Application Ref:	3/2026/0227			 Ribble Valley Borough Council www.ribblevalley.gov.uk
Date Inspected:	28/04/2026	Site Notice:	28/04/2026	
Officer:	MC			
DELEGATED ITEM FILE REPORT:				REFUSAL

Development Description:	Retrospective application for the raising of eastern wing roof and 'covering' of the former yard/pens and alterations to fenestration. Proposed change of use from agricultural to holiday let.
Site Address/Location:	Lodge at Winkley Hall, Whalley Road, Hurst Green, BB7 9PN

PL.02

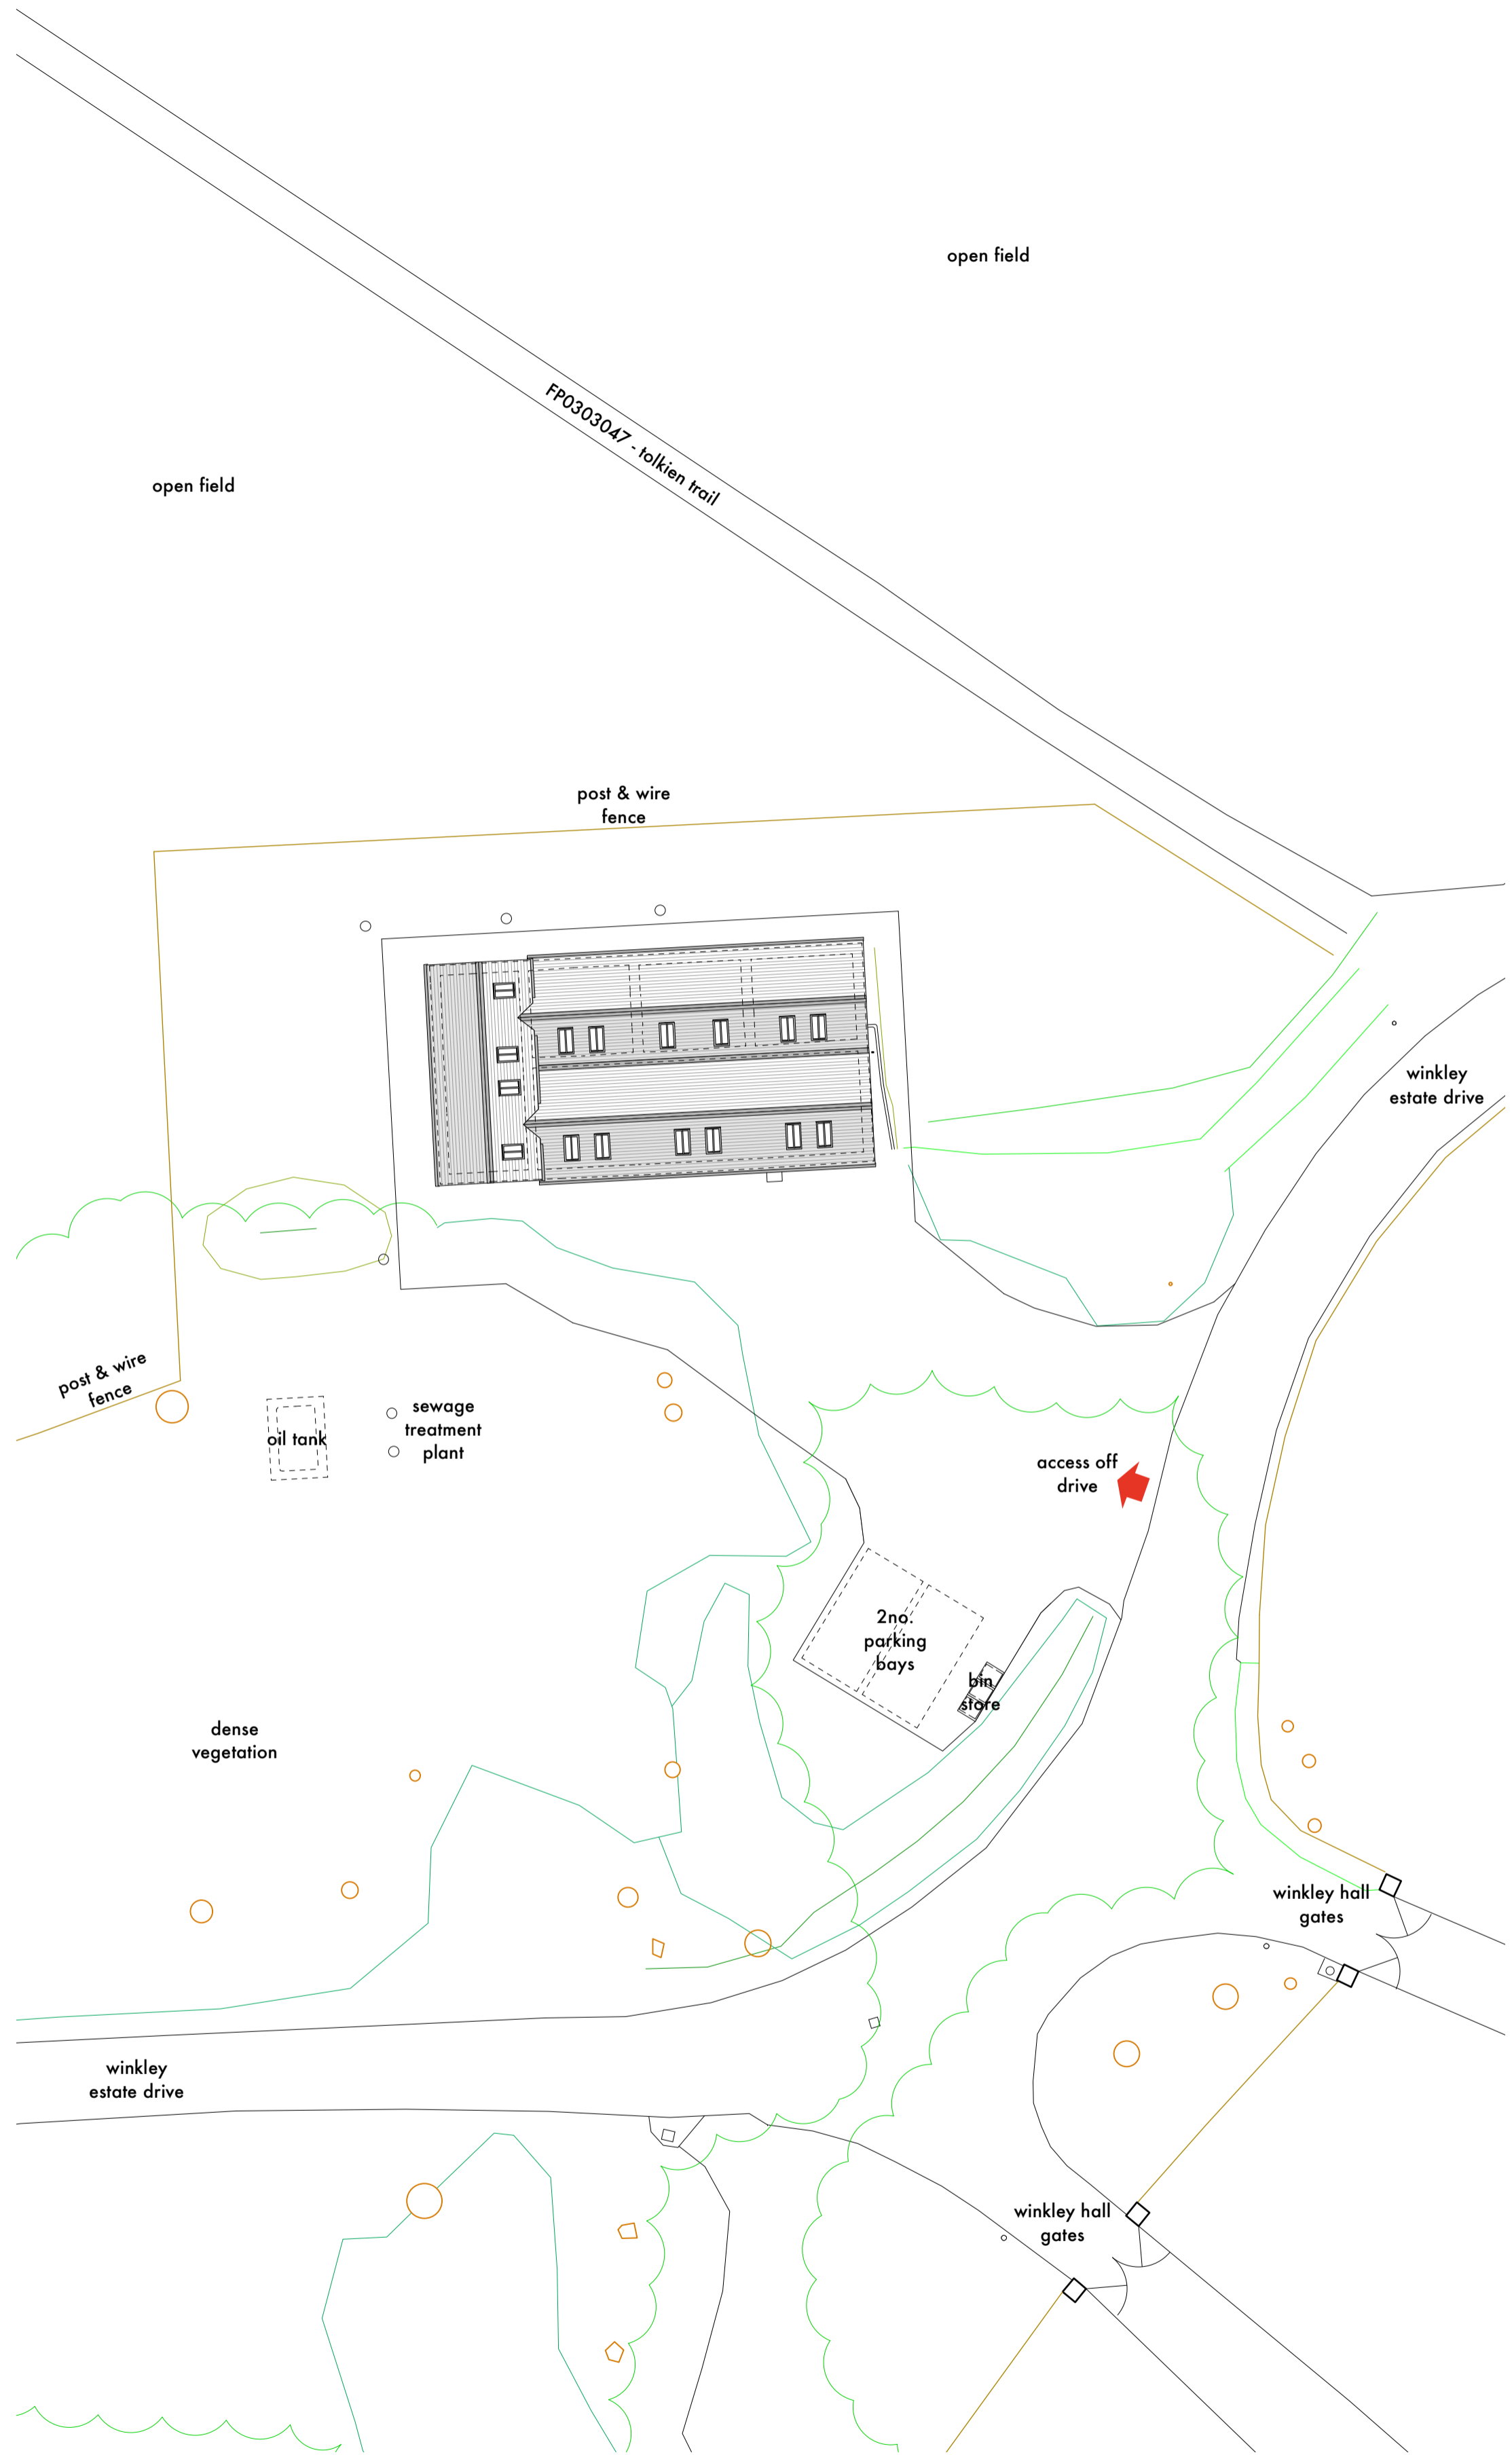
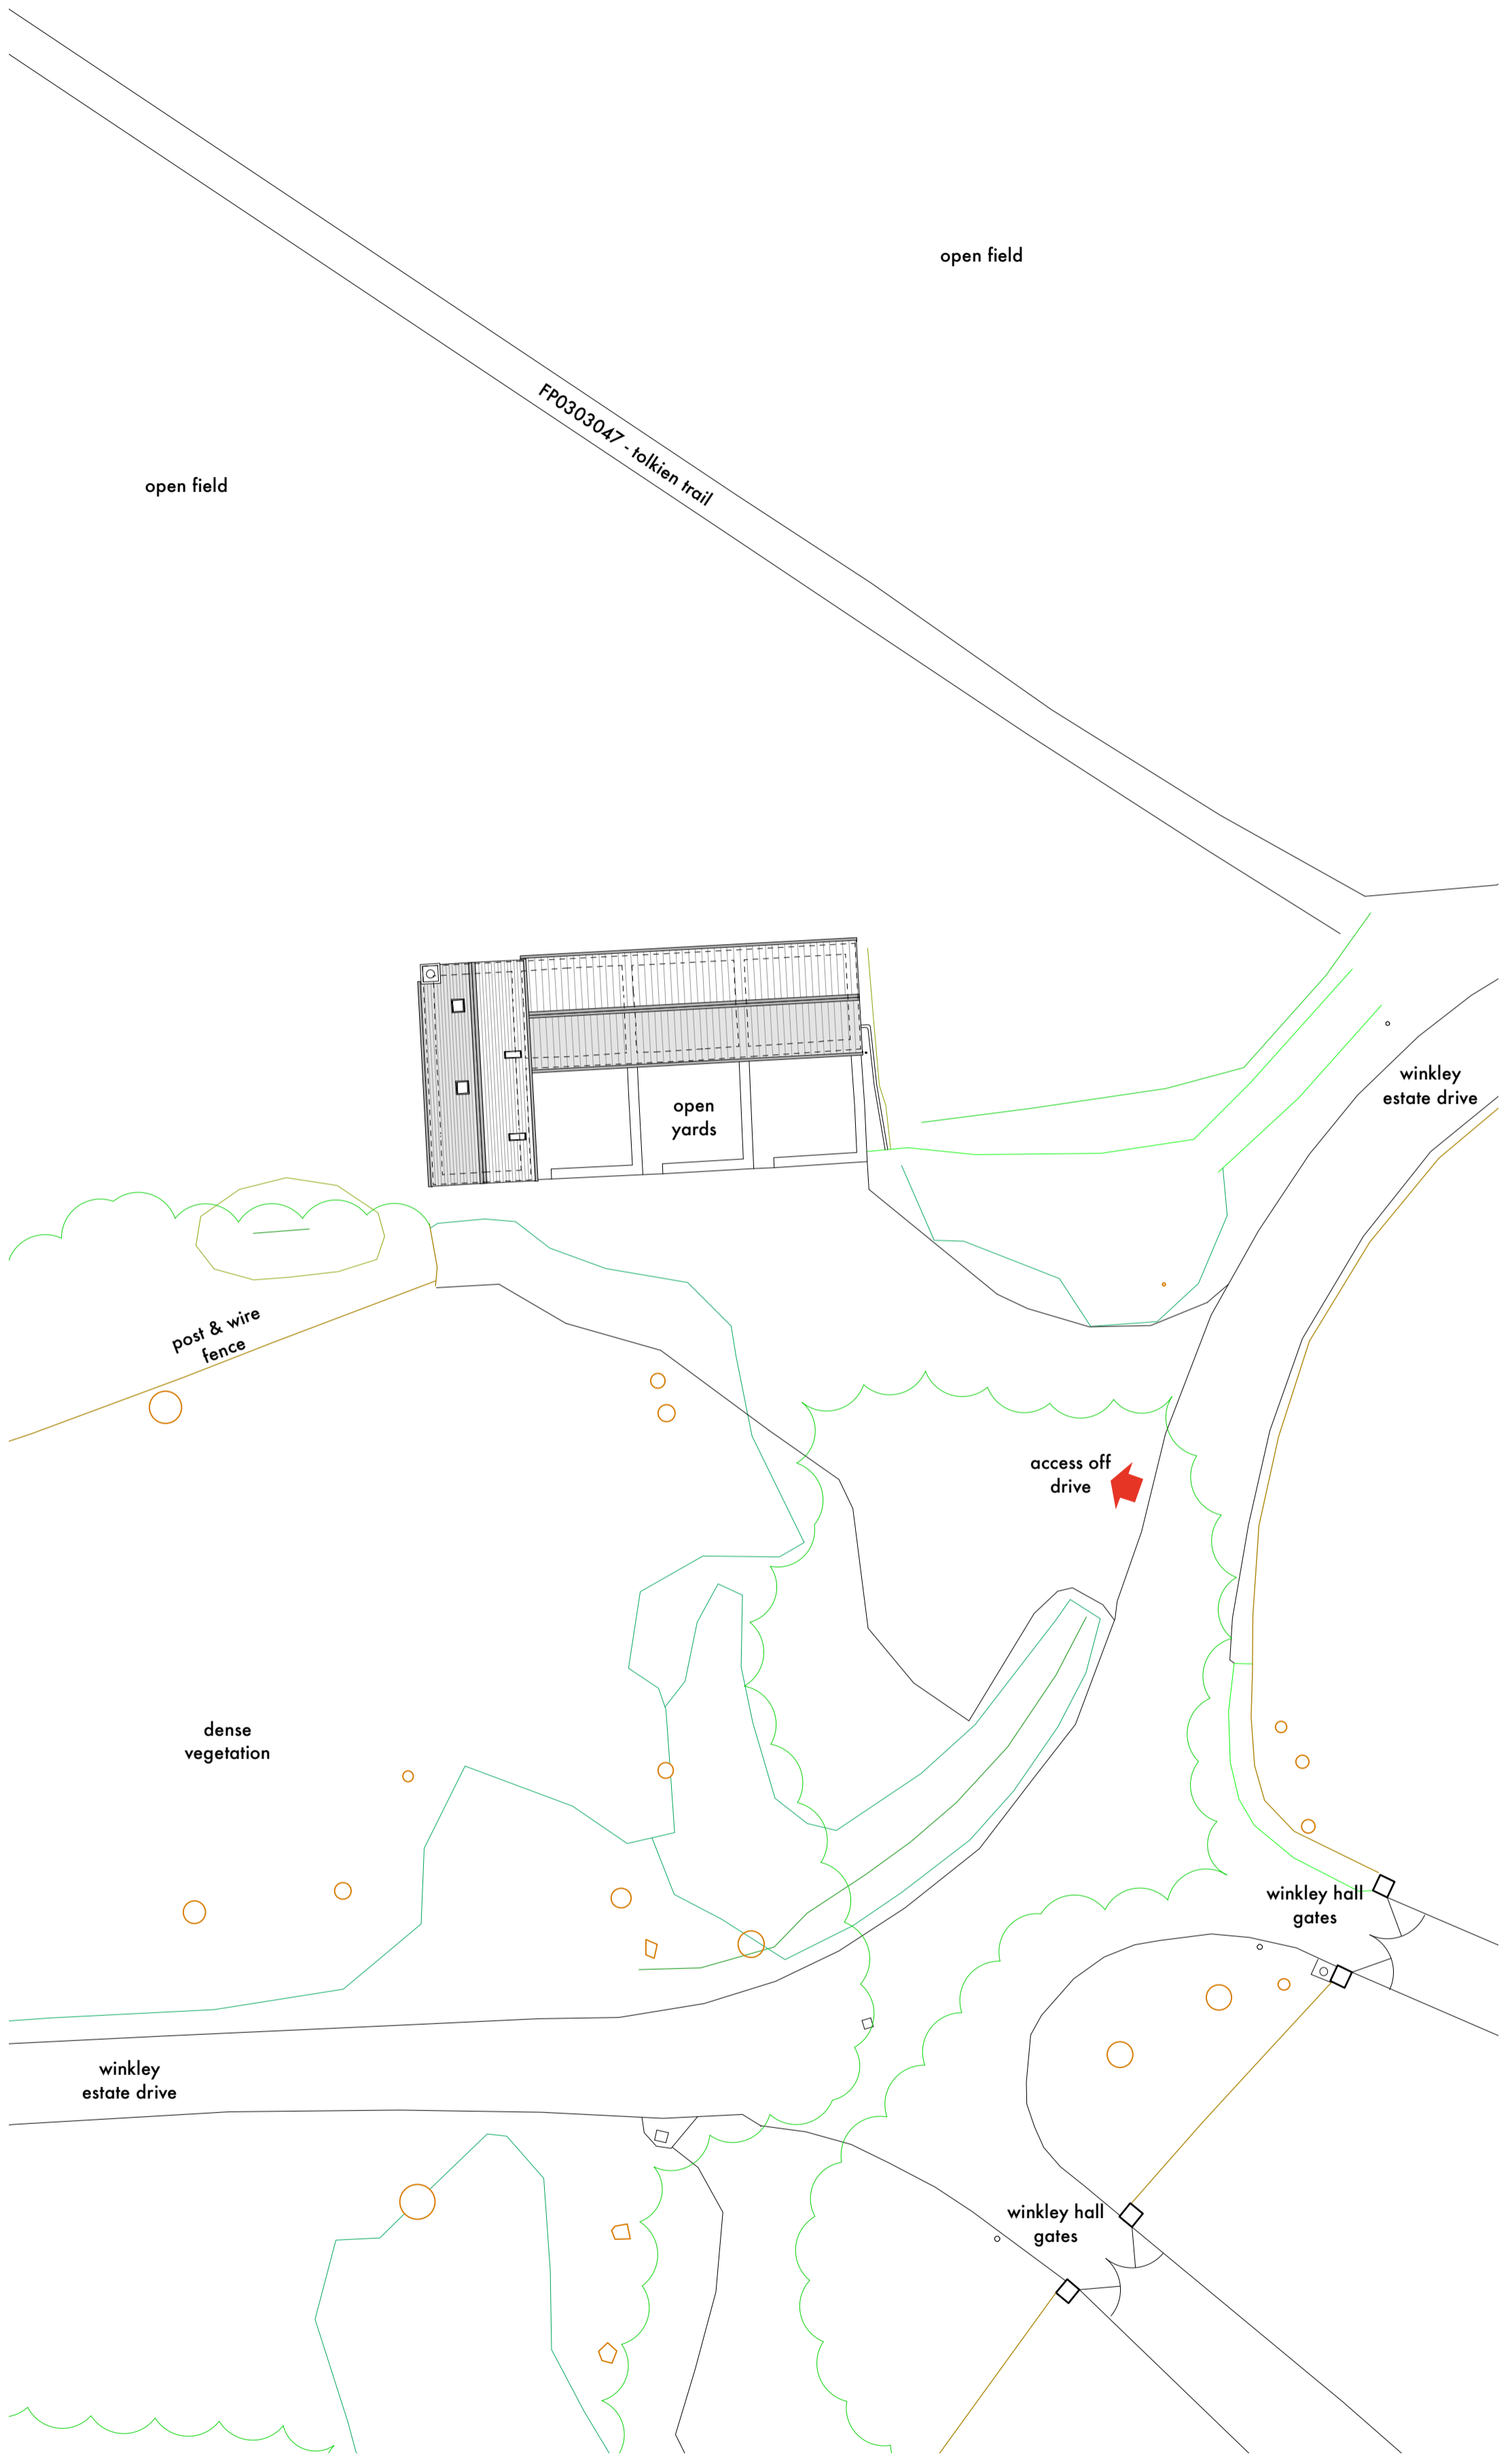
In addition to this, the site plan shows (and it has been confirmed on site) that a post and wire fence has been erected around the site boundary. As such, this would result in the introduction of domestic curtilage for use by the occupiers of the holiday let and inevitably lead to domestic paraphernalia such as tables, chairs and barbeques which would collectively result in a harmful, urbanising impact on the site, with this impact being discernible in the public realm from Public Right Of Way FP0303047. The site is considered to be widely visible from within the public realm as Public Right of Way FP0303047 forms part of the 'Tolkein Trail' which is a popular walking route in the Borough.
